SDNP/24/00924/TPO

Proposal: T1 - Red Oak, Rear of property, Reduce height and spread by a maximum of 3 metres, remove deadwood and broken branches.
To reduce risk of branch/stem failure and improve light to property.

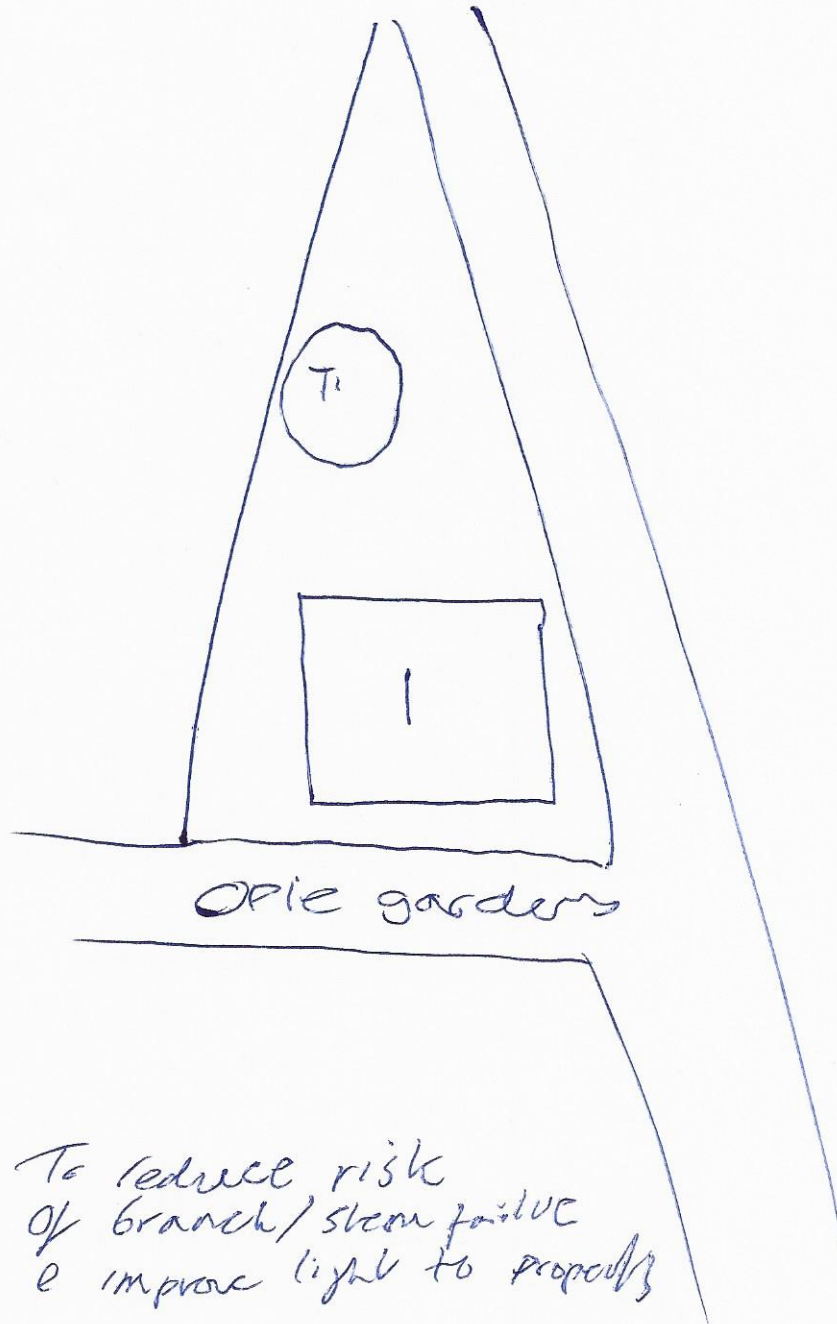
It is to the north of the property so the light impact should be limited.

I think the quality of the sketch makes it difficult to comment properly

The arboricultural officer should review.
